# CITY OF PORTLAND BUILDING PERMIT

Located At 26 THOMAS ST

Job ID: 2012-07-4470-CH OF USE

has permission to Change of use to 1<sup>st</sup> floor on the far left building to be no more than 2,800 sq ft of floor for office with day care and place of worship. (MAXIMUM 14 EMPLOYEES IN OFFICE AS PER CONDITIONAL RE-ZONING)  
provided that the person or persons, firm or corporation accepting this permit shall comply with all of the provisions of the Statutes of Maine and of the Ordinances of the City of Portland regulating the construction, maintenance and use of the buildings and structures, and of the application on file in the department.

date July 16, 2012
scale 1/4" = 1'-0"
project # 2012-018
drawing title **Floor Plan,
Partition Details**
drawing number **A101**

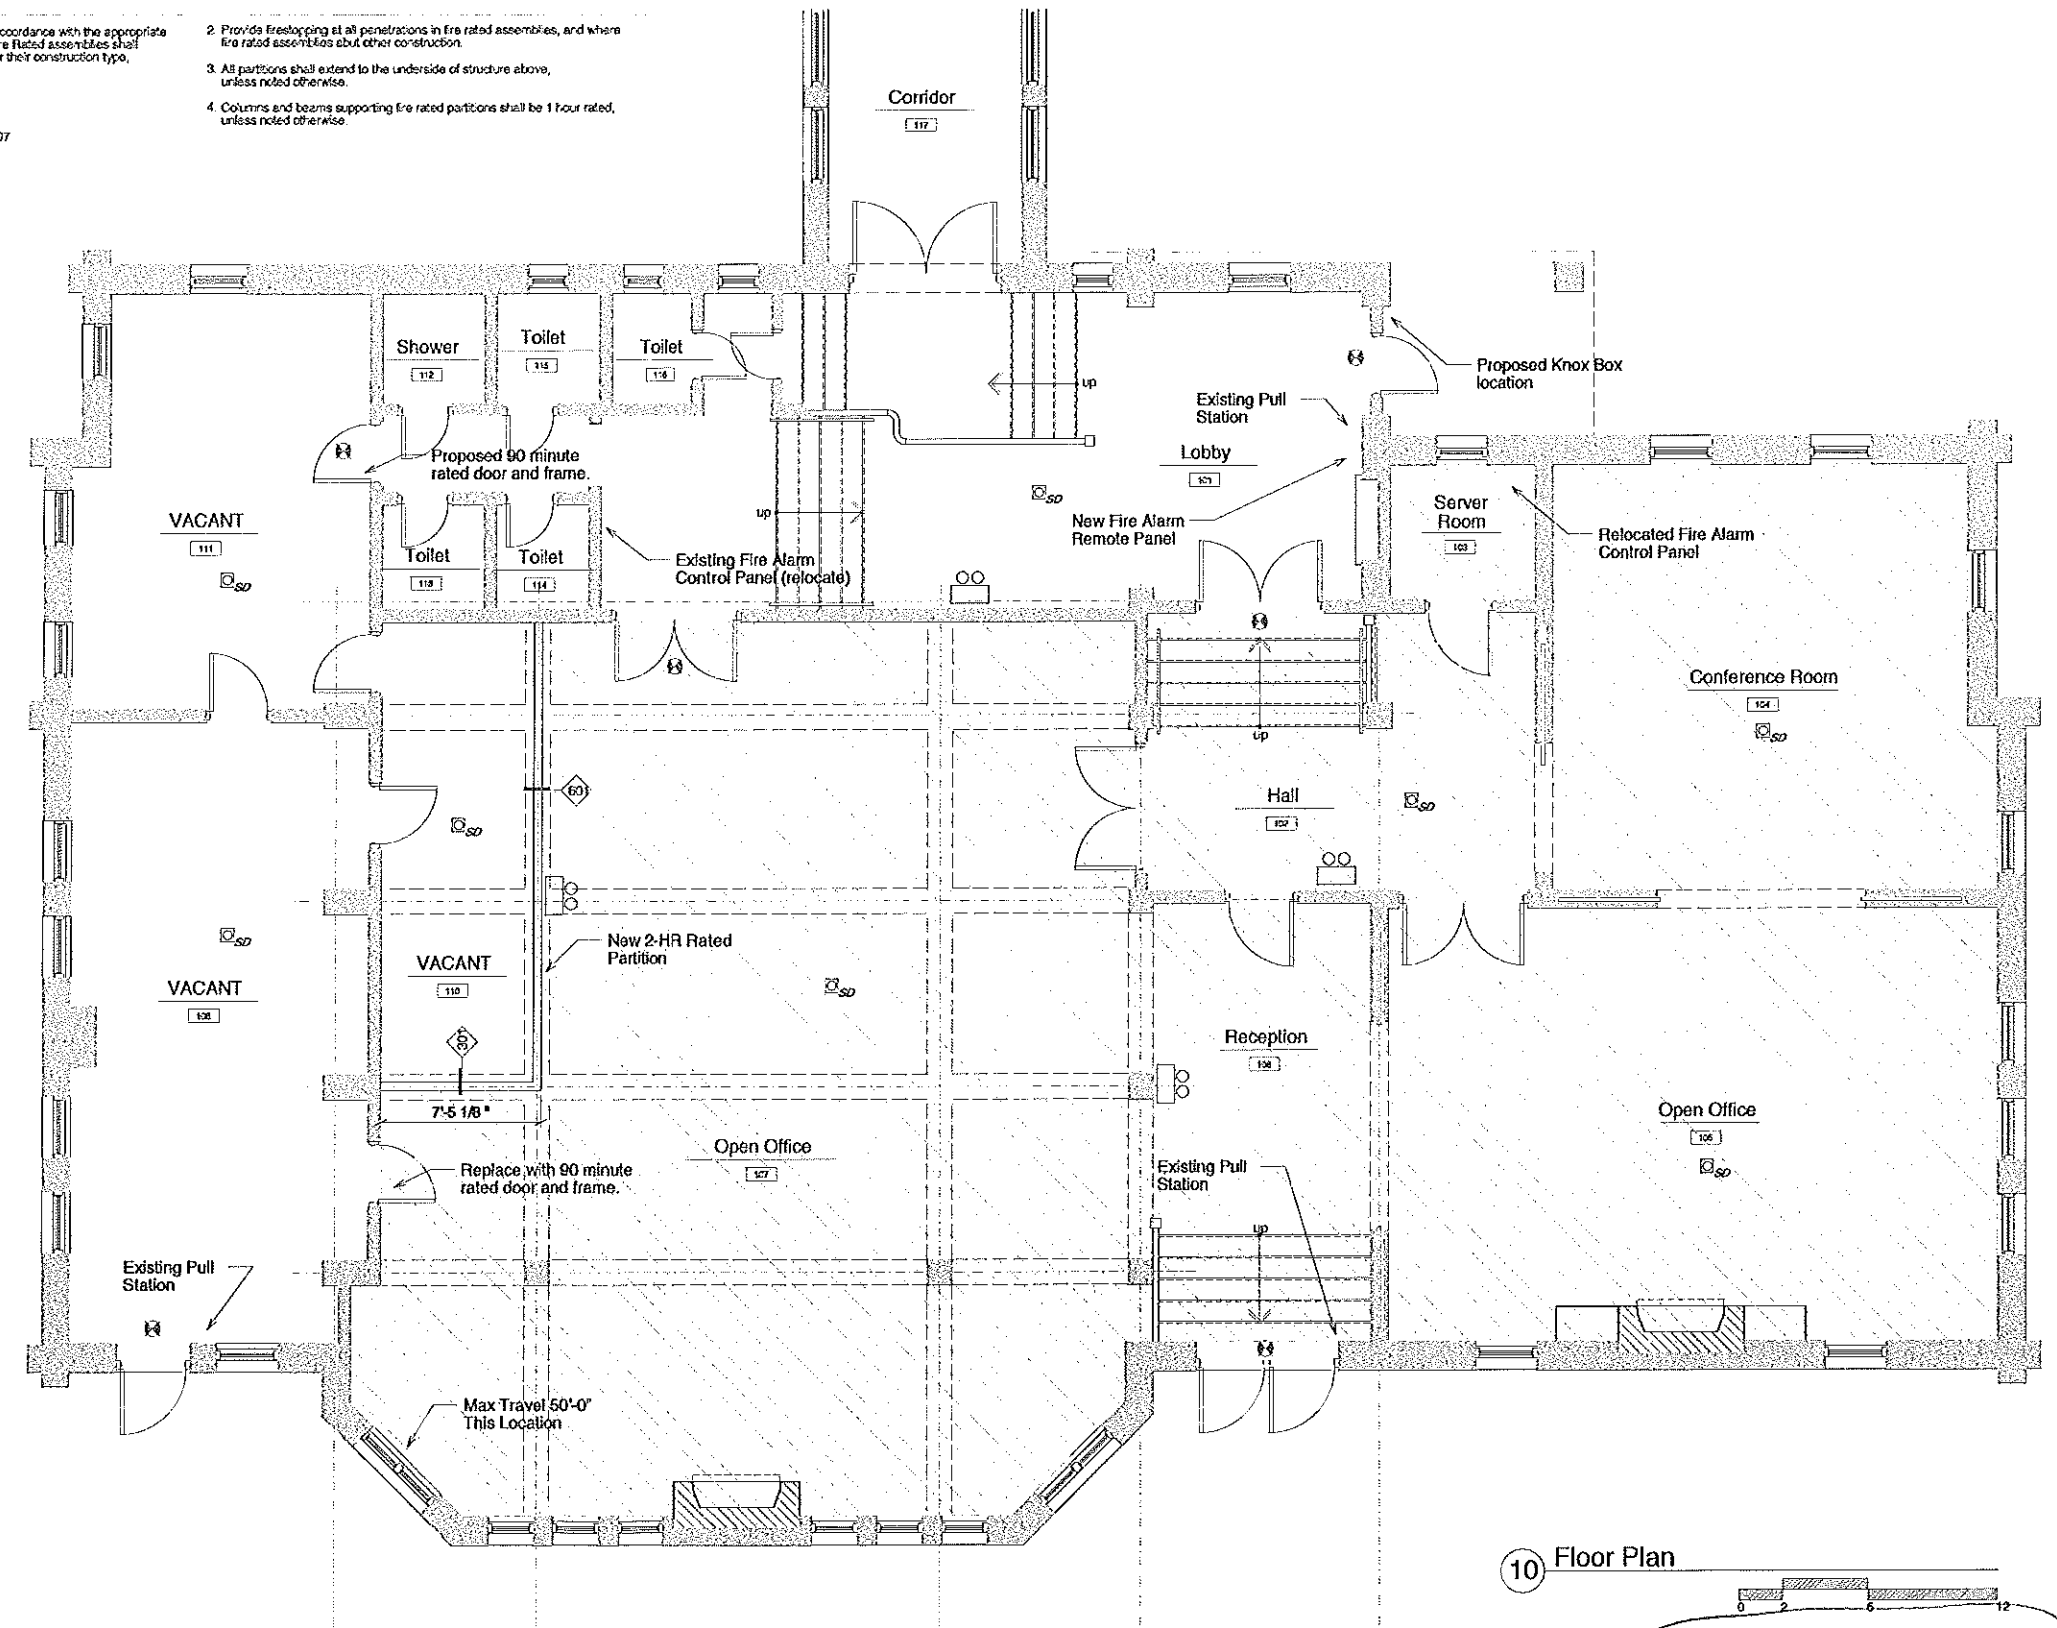
1. Sections of the first floor identified as vacant on plan A101 and the upper floors of the old parish house shall remain vacant. Vacant spaces shall remain vacant from all uses until additional permits are approved and certificate of occupancy issued for those spaces.
